Grading & Erosion Control Plan_V2 redlines.pdf Markup Summary

3-22-2022

SHT. NO. 3 OF 5
EDB OUTLET DETAILS

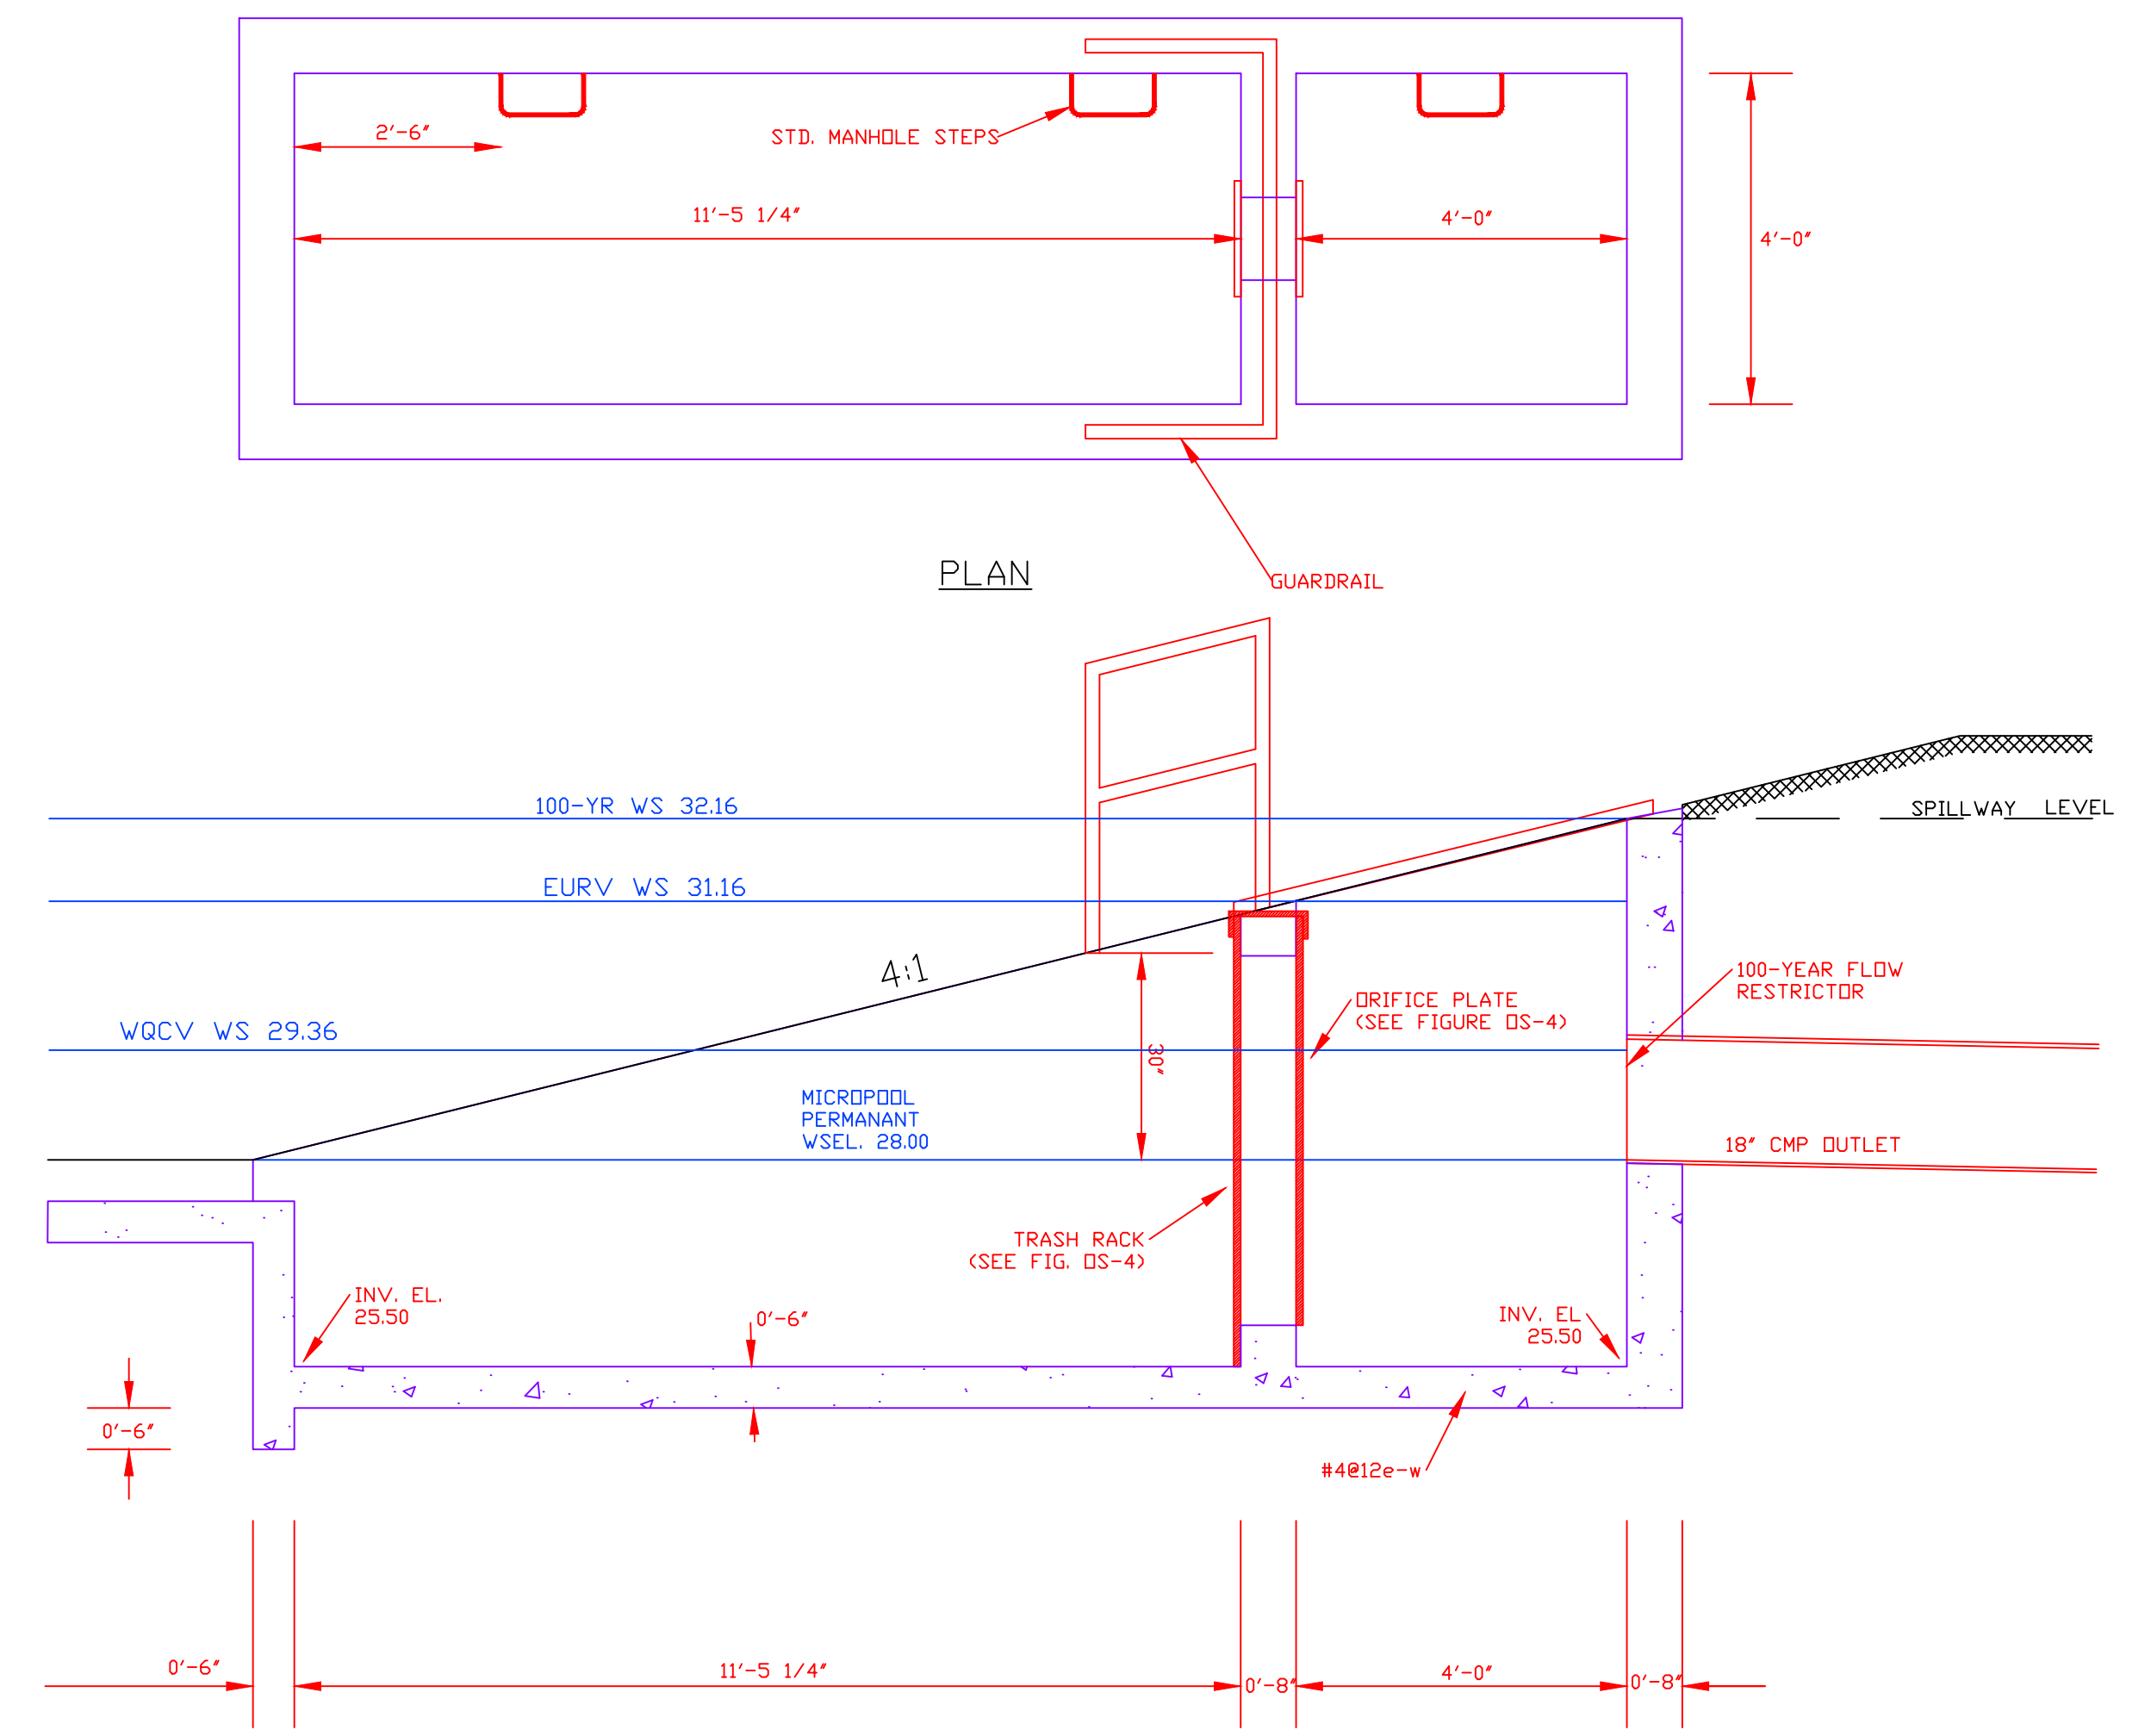
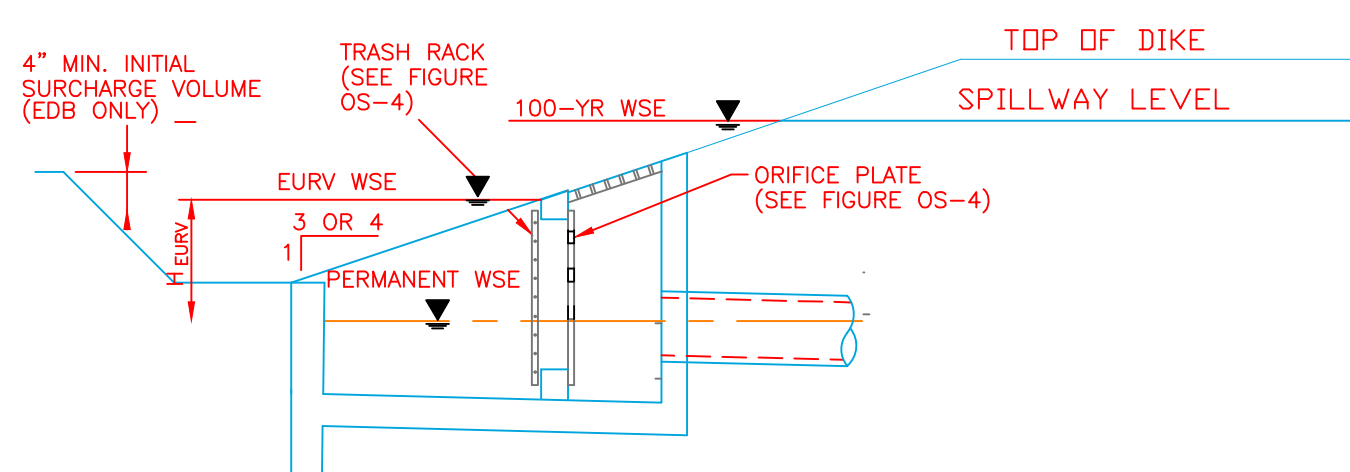
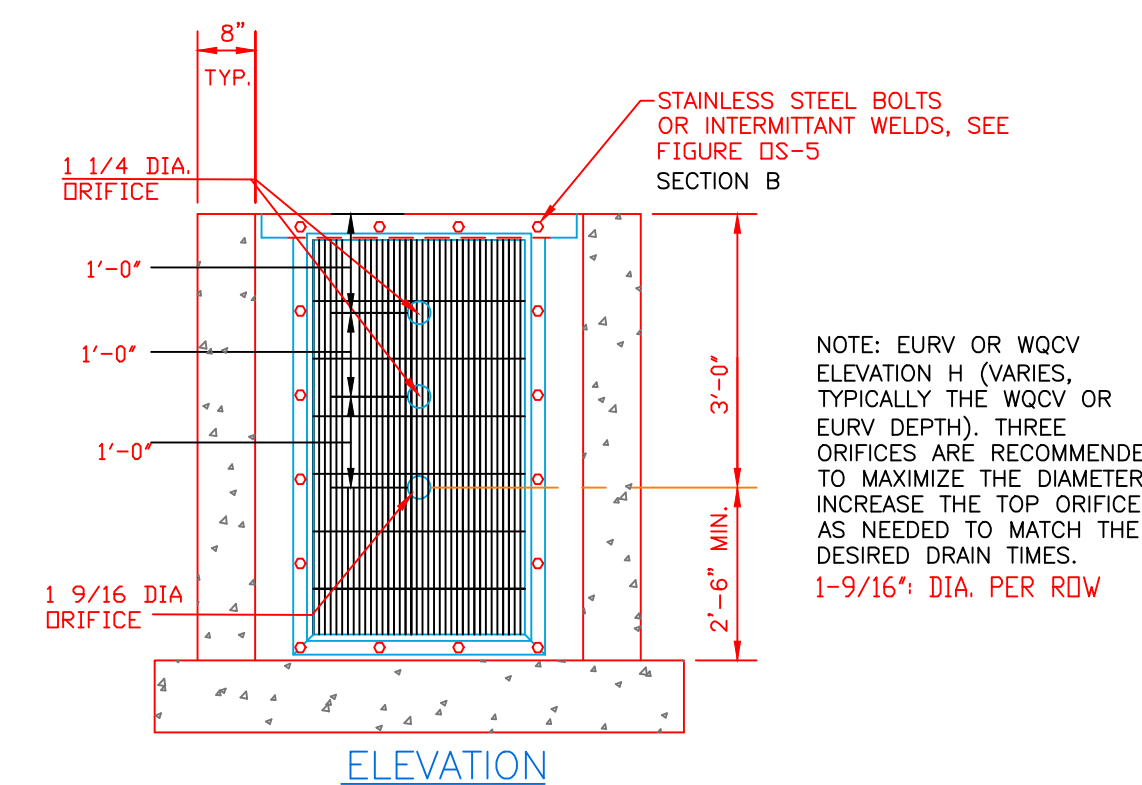
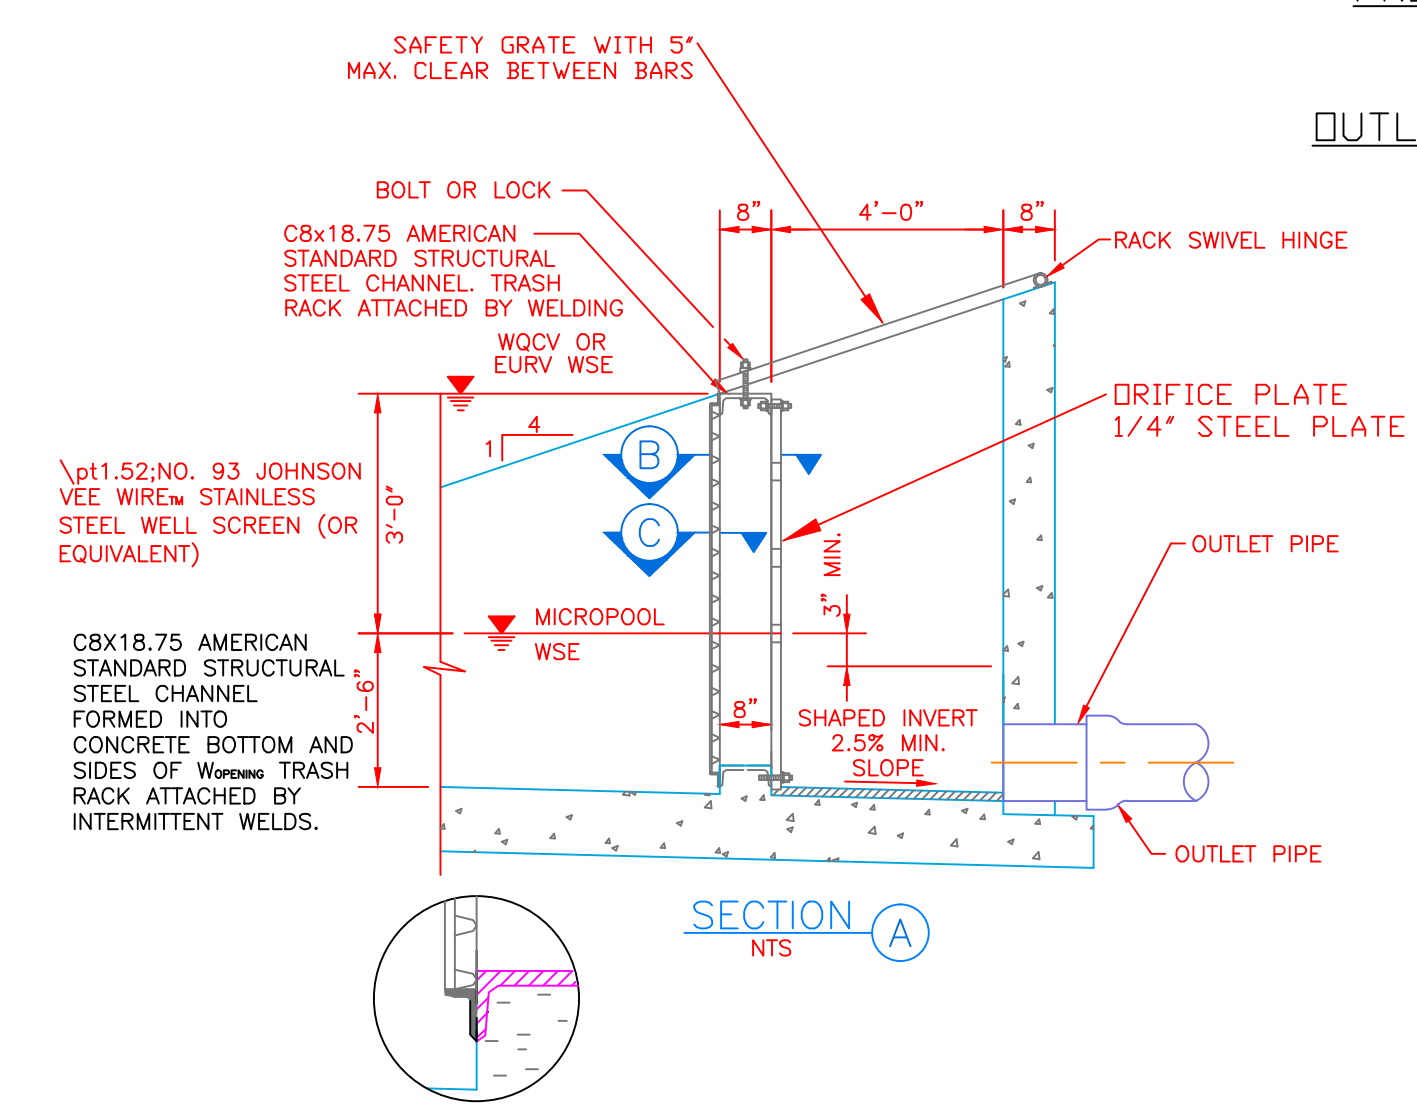
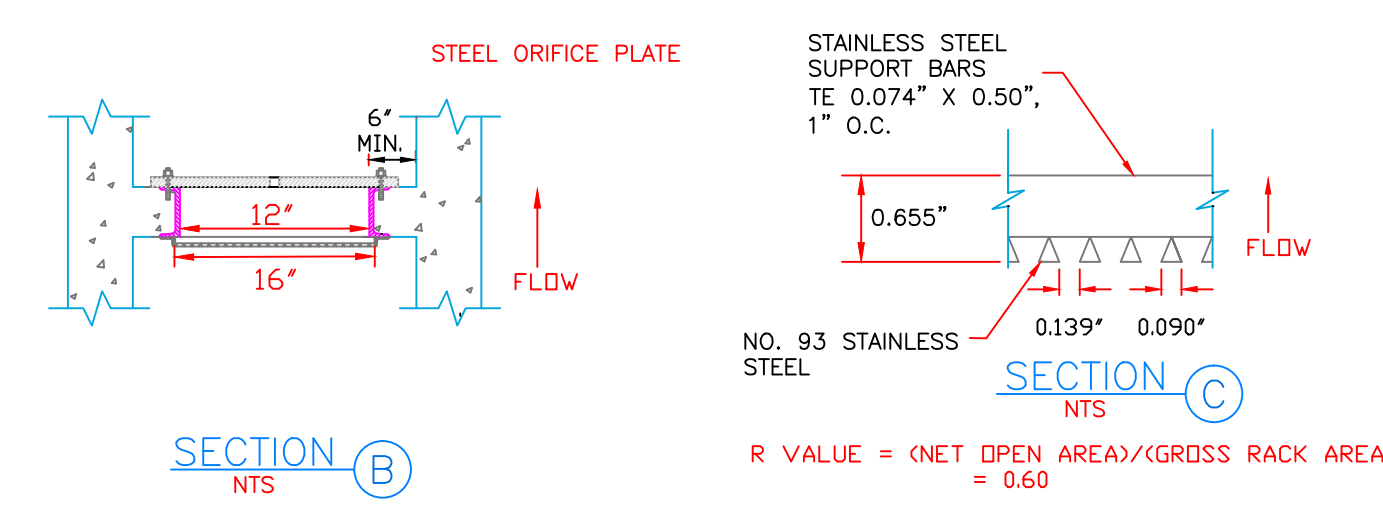
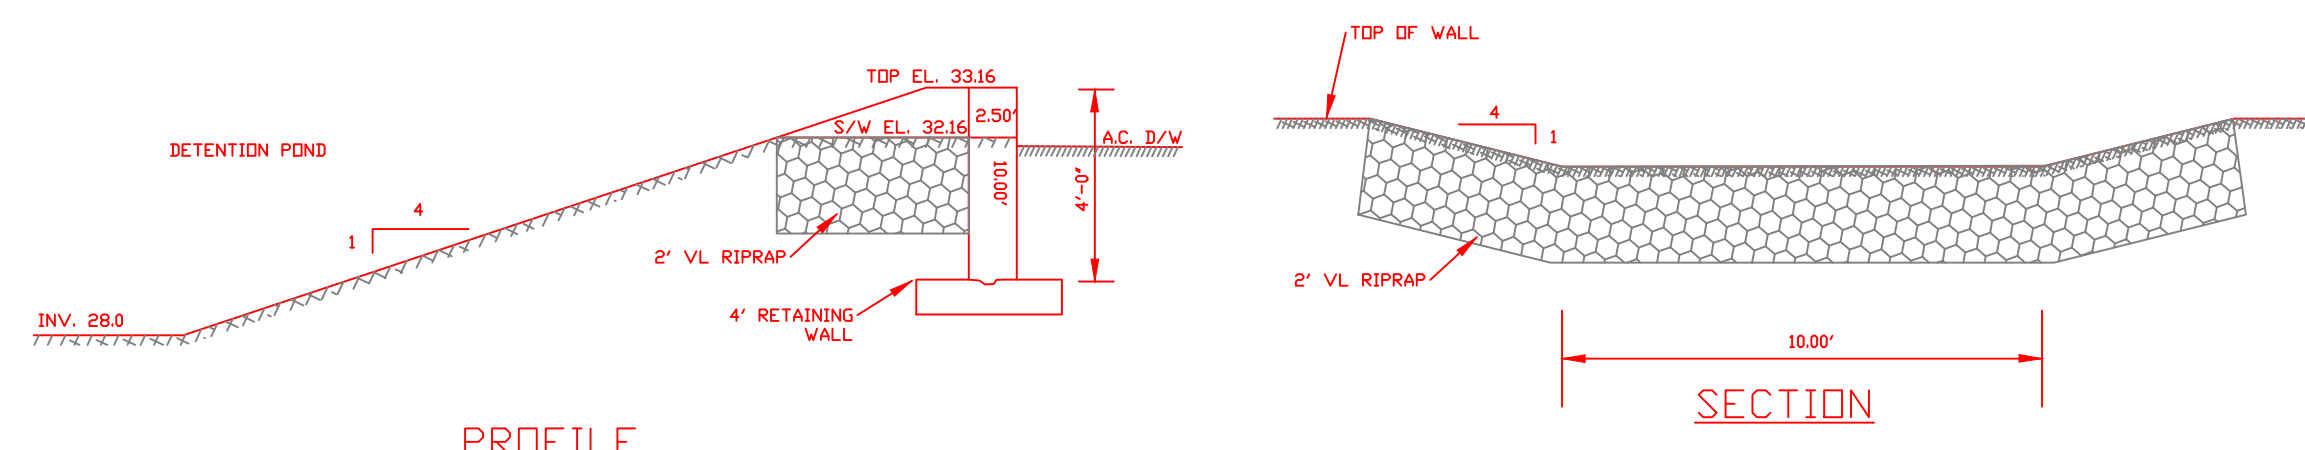
provide width of plate

You have 4 different details for outlet structures, all with conflicting information. Please chose one for design and construction.

what is this clearance?

Pond bottom should have a minimum slope of 3% to the trickle channel and micropool (USDCM Vol 3, detail T-5).

include trickle channel slope to micropool

provide spillway details

invert

Per DCM V2 Section 4.3, outlet pipe should be 18" minimum.

Figure 6B, page 4-128 minimum outlet pipe size 18"

Please add invert to this location

Ollie please change to OS-4

Change figure OS-1 to cross section A

Details from Urban Drainage provided to Ollie. Please make sure to update FAE to include riprap amounts
